Our Reference: V13/301
OUT13/36946

**Proposed Bringelly Brick Works (SSD-5684)
Environmental Impact Statement**

NSW Trade & Investment, Division of Resources and Energy (DRE) has reviewed the *Bringelly Brickworks EIS, 6 November 2013* and provides the following comments which are directed at specific areas of DRE's responsibility for this proposal:

APPENDIX 4 CONCEPTUAL FINAL LANDFORM AND BIODIVERSITY OFFSET STRATEGY

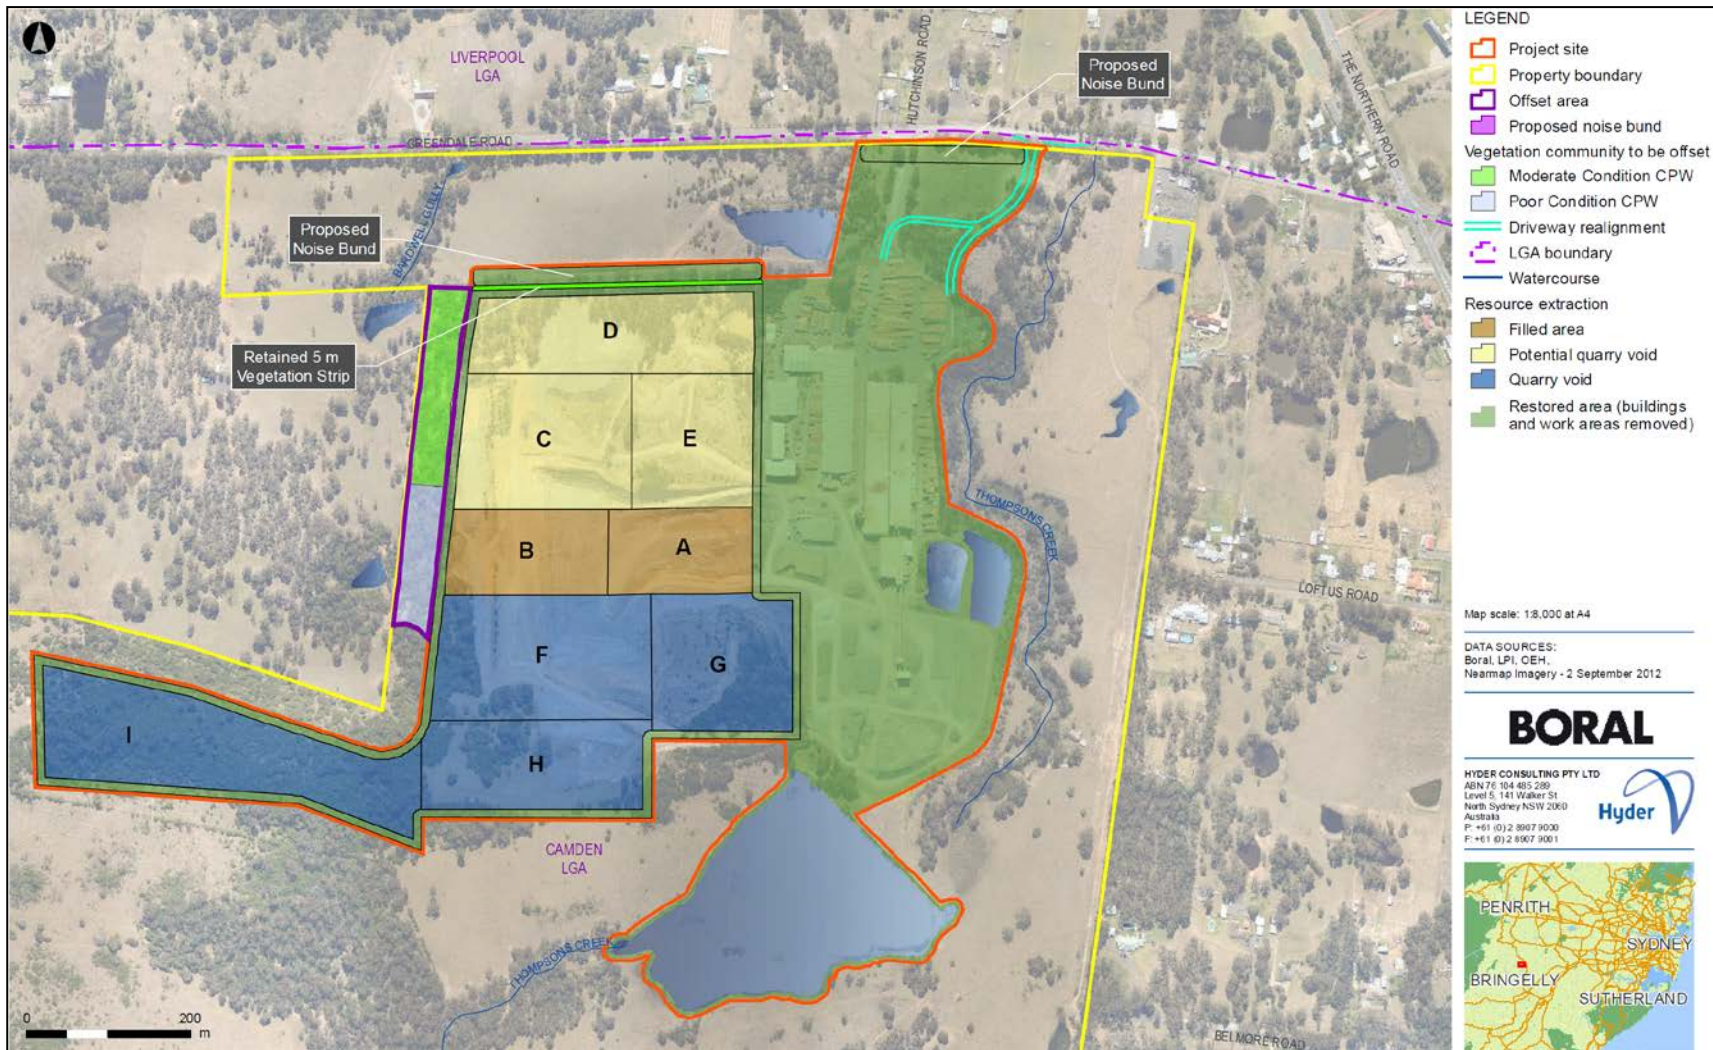
DRE does not believe the proposed rehabilitation will result in a satisfactory rehabilitation outcome. In particular, the proposal to leave extensive, non vegetated, final voids, with either steep or benched slopes is not acceptable.

The proposed rehabilitation outcome is not consistent with the surrounding landform or land use and it is uncertain which of the potential future identified land uses will actually be selected, nor is there an explanation as to why the these landforms are acceptable.

The proposed final void appears to have little beneficial use other than for landfill, which is not confirmed as a feasible option at this stage and has the potential to greatly increase the cost for many forms of redevelopment.

Ideally, the default rehabilitation proposed in the EIS should result in a safe, stable, non-polluting landform consistent with the surrounding area in the event that none of the possible identified post mining land uses is deemed appropriate at the time of mine closure.

Alternative potential land uses identified (including landfill, industrial, residential or continued quarrying) should not be precluded by the proposed landform.
